CITY OF ALBUQUERQUE

July 15, 2021

Re: Lizard Tail Brewery
9800 Montgomery Blvd NE, Ste 7
Traffic Circulation Layout
Architect's Stamp 06-17-2021 (G21-D007)

REVISED SITE PLAN

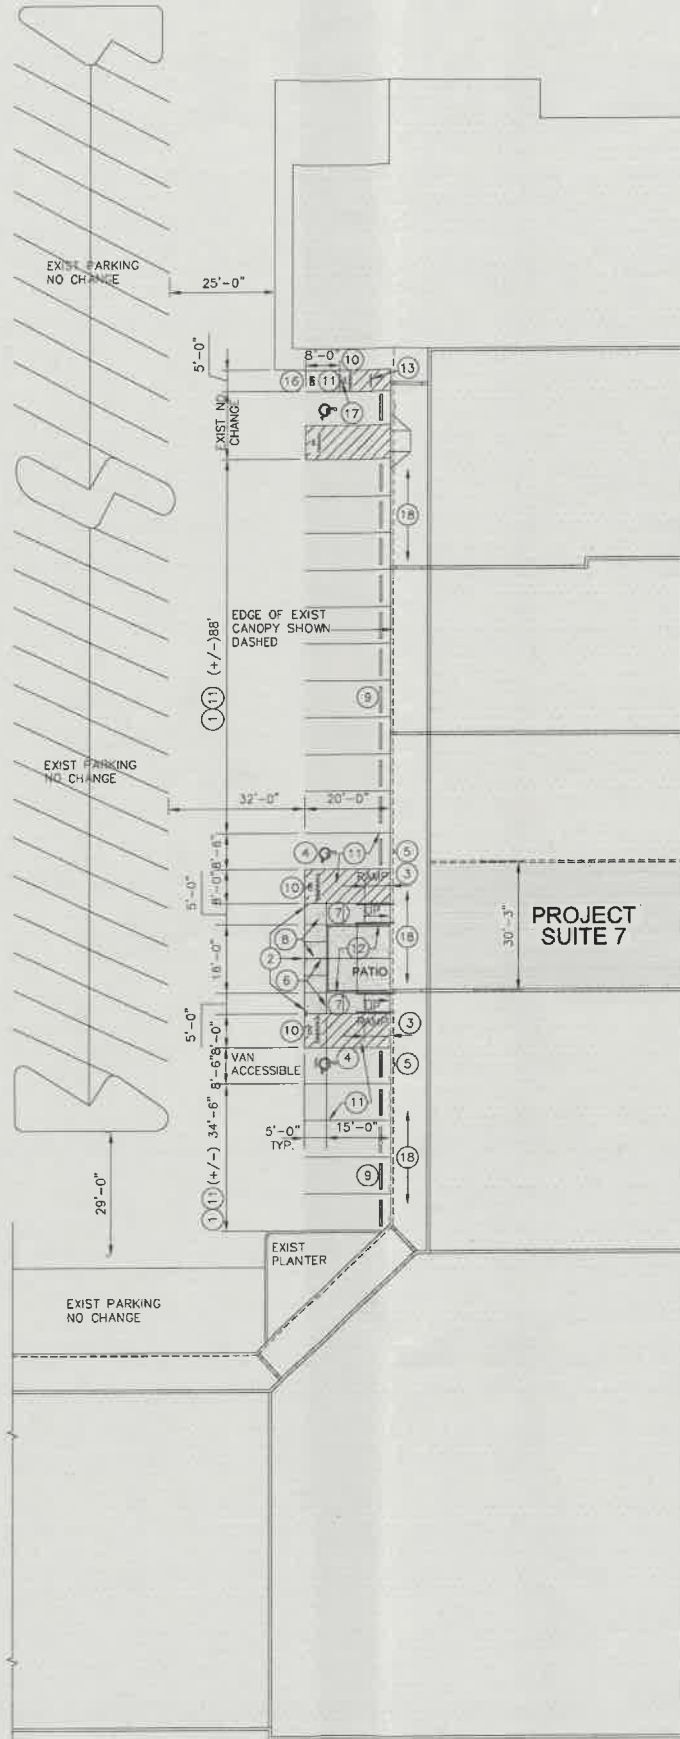
1. **Provide sidewalk width around the parameter of proposed Patio.**
2. **The ADA accessible parking sign must have the required language per 66-7-352.4C NMSA 1978 "Violators Are Subject to a Fine and/or Towing."** Please call out detail and location of signs.
3. Motorcycle parking spaces shall be designated by its own conspicuously posted upright sign, either free-standing or wall mounted per the zoning code. Label pavement MC.**What is the status for motorcycle parking spaces/ Explain.**

7. Show all drive aisle widths and radii. Some dimensions are not shown.
 8. Per DPM, a 6 ft. wide ADA accessible pedestrian pathway is required from the ADA parking stall access aisles to the building entrances. Please clearly show this pathway and provide details.

9. You cannot located ramp along side ADA access isle. This is a safety/hazard to ADA pedestrian traffic. Please provide a safer ramp location. So keyed note 7 will need to be adjusted.

10. Keyed note 11: for ADA the color needs to be blue.
11. Provide a copy of refuse approval.
12. Shared Site acces: driveways that straddle property lines, or are entirely on one propertybut are to be used by another property, shall have an access easement. Please include a copy of your shared access agreement with the adjacent property owner.

13. Add a note stating "All broken or cracked sidewalk must be replaced with sidewalk and curb & gutter." A build note must be provided referring to the appropriate City Standard drawing.

7 BICYCLE RACK DETAIL
N.T.S.

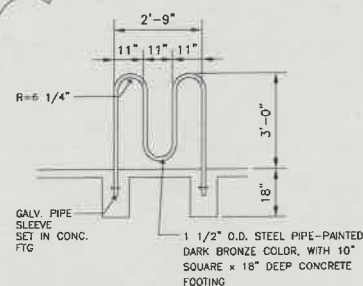
All bicycle racks shall be designed according to the following guidelines (What is the status ? Explain:

- a. The rack shall be a minimum 30 inches tall and 18 inches wide.
 - b. The bicycle frame shall be supported horizontally at two or more places. Comb/toaster racks are not allowed.

- c. The rack shall be designed to support the bicycle in an upright position. See the IDO for additional information.
 - d. The rack allows varying bicycle frame sizes and styles to be attached.

- e. The user is not required to lift the bicycle onto the bicycle rack.
 - f. Each bicycle parking space is accessible without moving another bicycle.

4. Bicycle racks shall be sturdy and anchored to a concrete pad.
 5. A 1-foot clear zone around the bicycle parking stall shall be provided.
 6. Bicycle parking spaces shall be at least 6 feet long and 2 feet wide.
